Subject: RE: BN/50/20/PL Land W of Fontwell Avenue - Design Comments

Site Plan (reference: 29662A_100_RevV)

SCHEDULE OF ACCOMMODATION

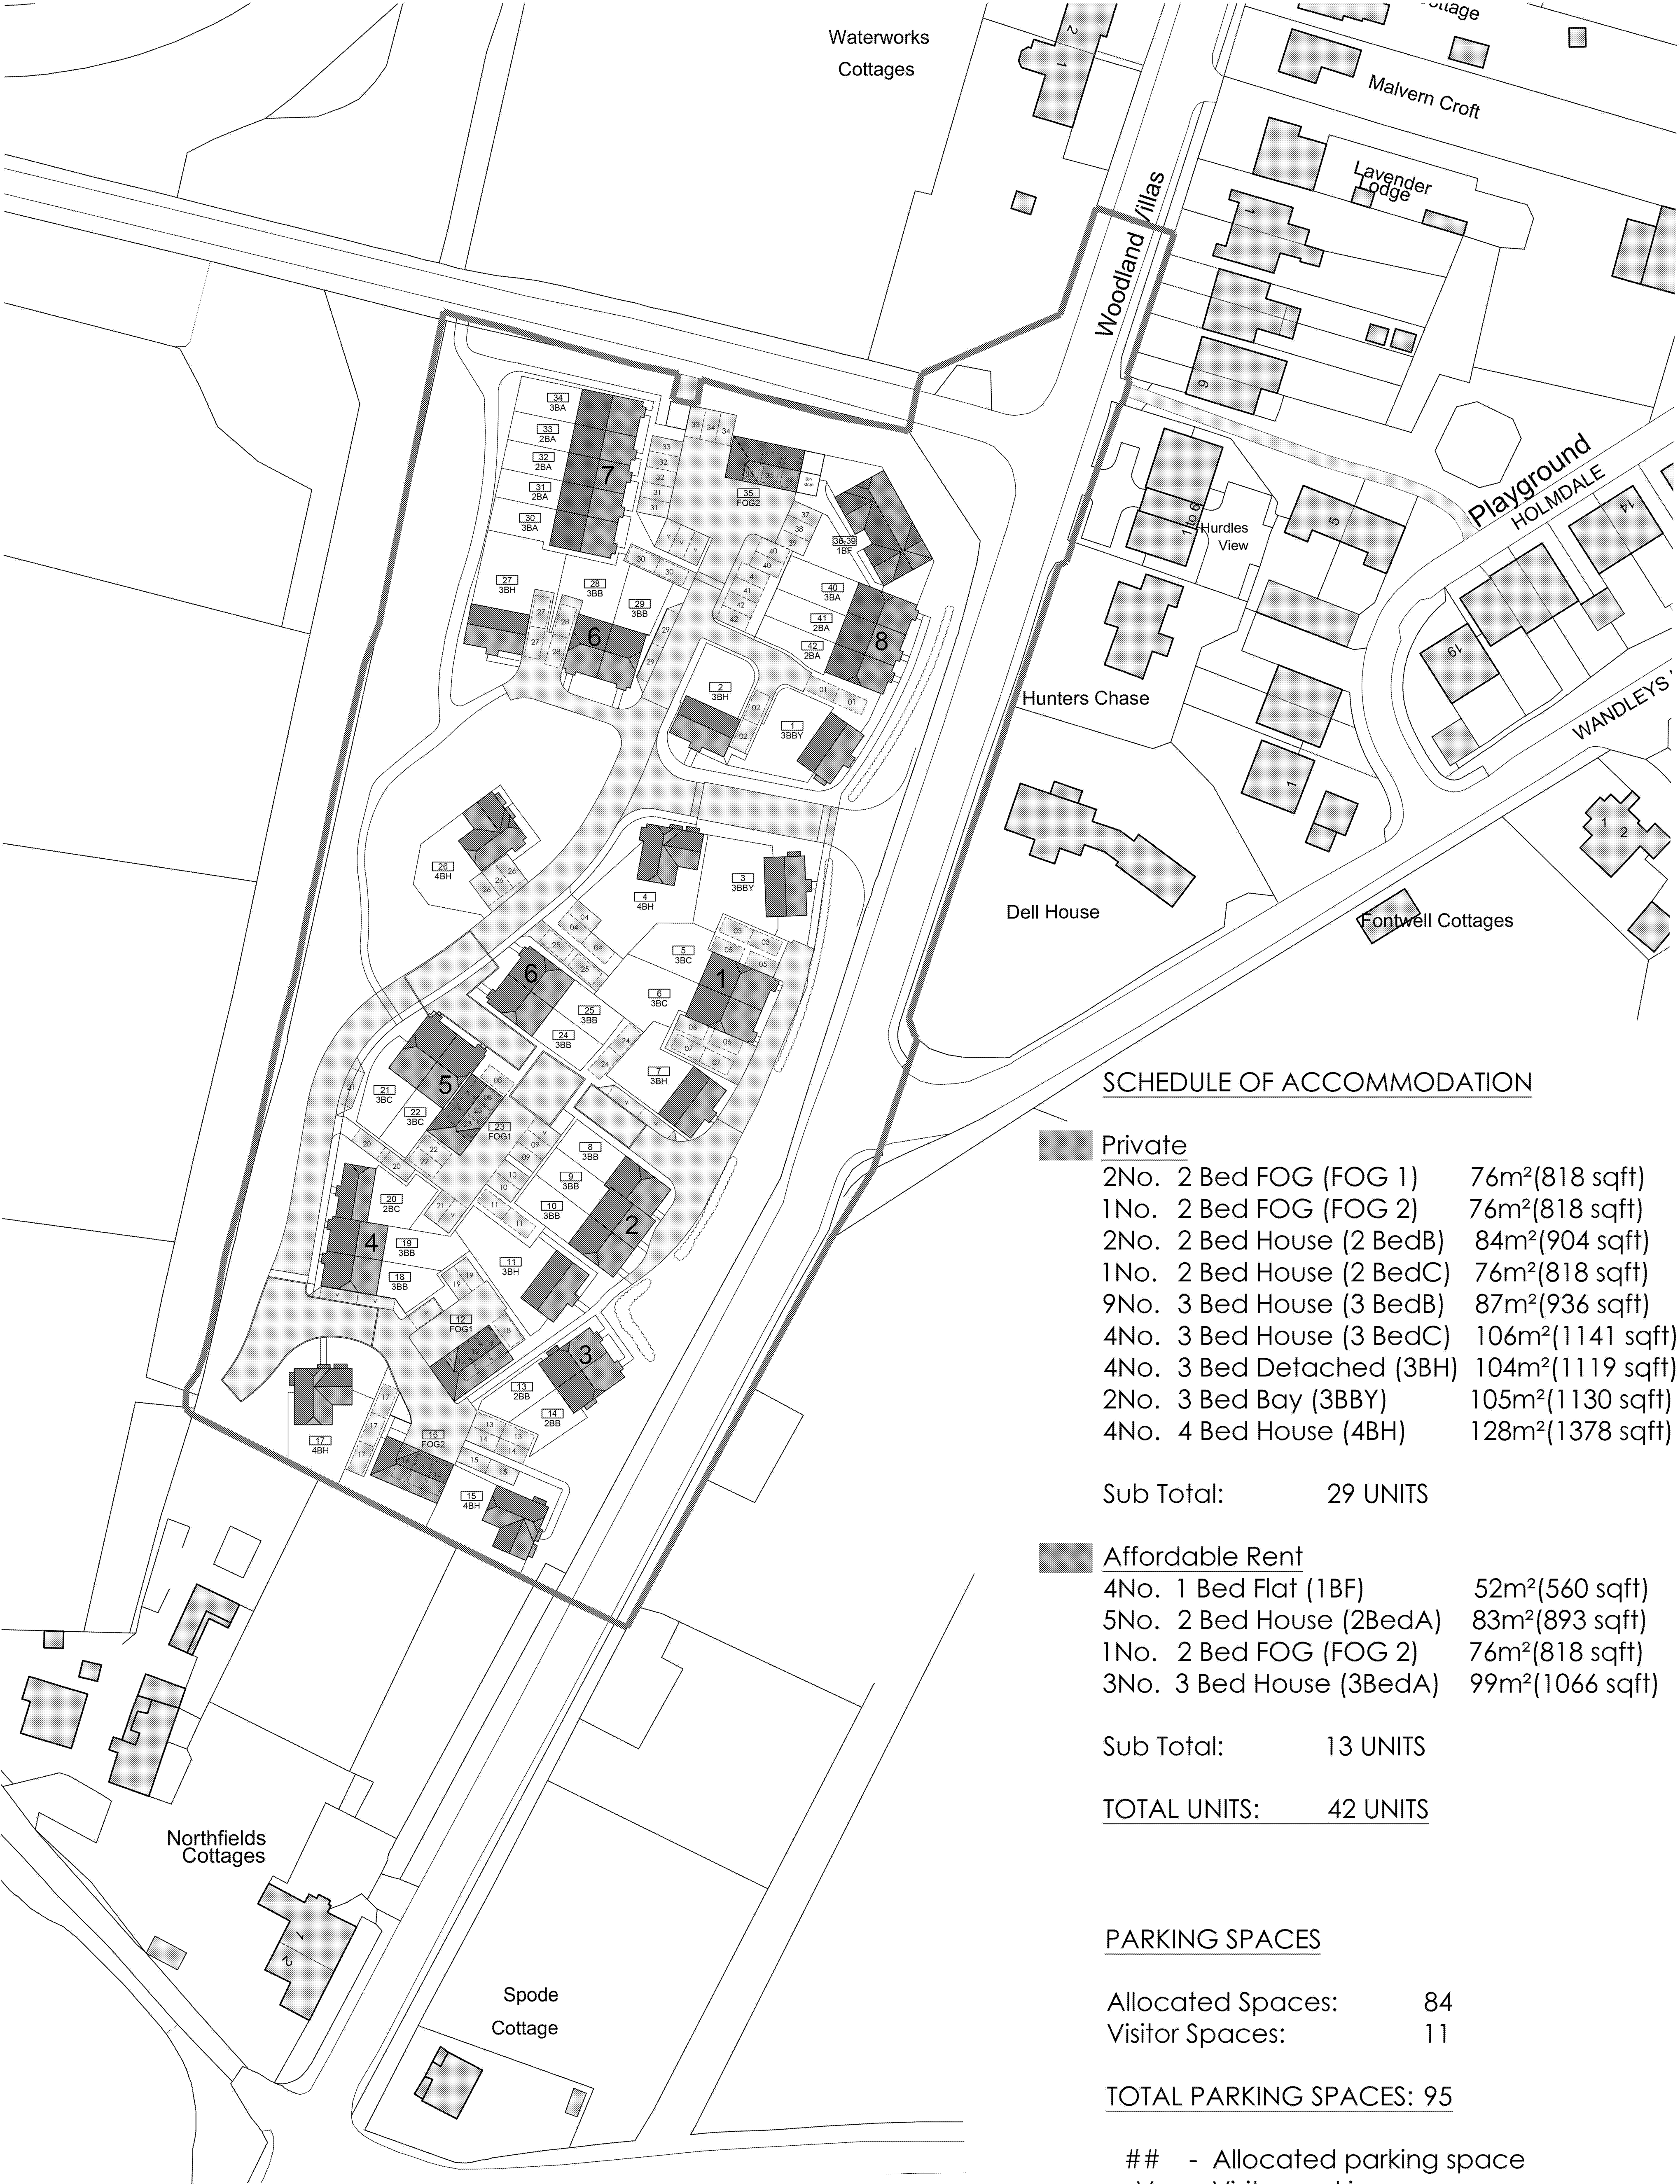
- Many of the residential gardens are not 10.5m in length (as per emerging Arun Design Guide). I have measured some in the range of 8-9m long.
- Plots 12, 16, 23, 35 are first floor only with garage parking below. I don't think these can be termed flats. They seem to have either very little strips of garden or none at all and in all cases do not meet the garden length as per the SPD.

- Plots 36-39 (Flats) don't have enough garden to meet Design Guide (they need either balconies of at least 3sqm of useable space or a residential communal shared space of 40sqm plus 10sqm for each unit (so 80m² in total).

- The parking proposal vs the requirement is off. Your plans show 66 on plot spaces, 22 garage spaces (note that the schedule Rev L says 18 and I think miscounts the number of garage spaces in plots 12/16/23/35) & 10 visitor spaces. Garages are treated as half a space in the Arun Parking Standards SPD therefore the proposal is 87. The requirement on the other hand is 96. I accept that our policy allows for 10% variation if a Travel Plan is provided and that you have supplied one. However, I'm not convinced that this is sufficient to warrant an under provision particularly given the countryside location. You could swap out the 10 detached garages for car ports and thus gain 5 proposed spaces which would help and may om balance allow this to be overcome. Incidentally, there are no plans that I can see of the 10 single garages. Please provide these or if swapping with car ports then provide plans of those.

- Plots 4-5 - rear garden fences altered to increase plot 5 garden.
- Plots 8-10 – gardens increased in length by moving houses southeast.
- Plots 30-31 – gardens increased in length by moving houses southeast.
- Plots 36-39 – communal amenity space now includes land to the front of building.
- Plots 40-42 – garden reduced in length to allow for additional planting behind car parking.

- The level of parking provided is compliant with ADC's Parking standards.
- ADC's parking standards allow for a 10% variation to be provided if a Travel Plan, travel incentive or public transport contributions are provided. There are no restrictions on where this variation can be applied as long as the required incentives are provided.
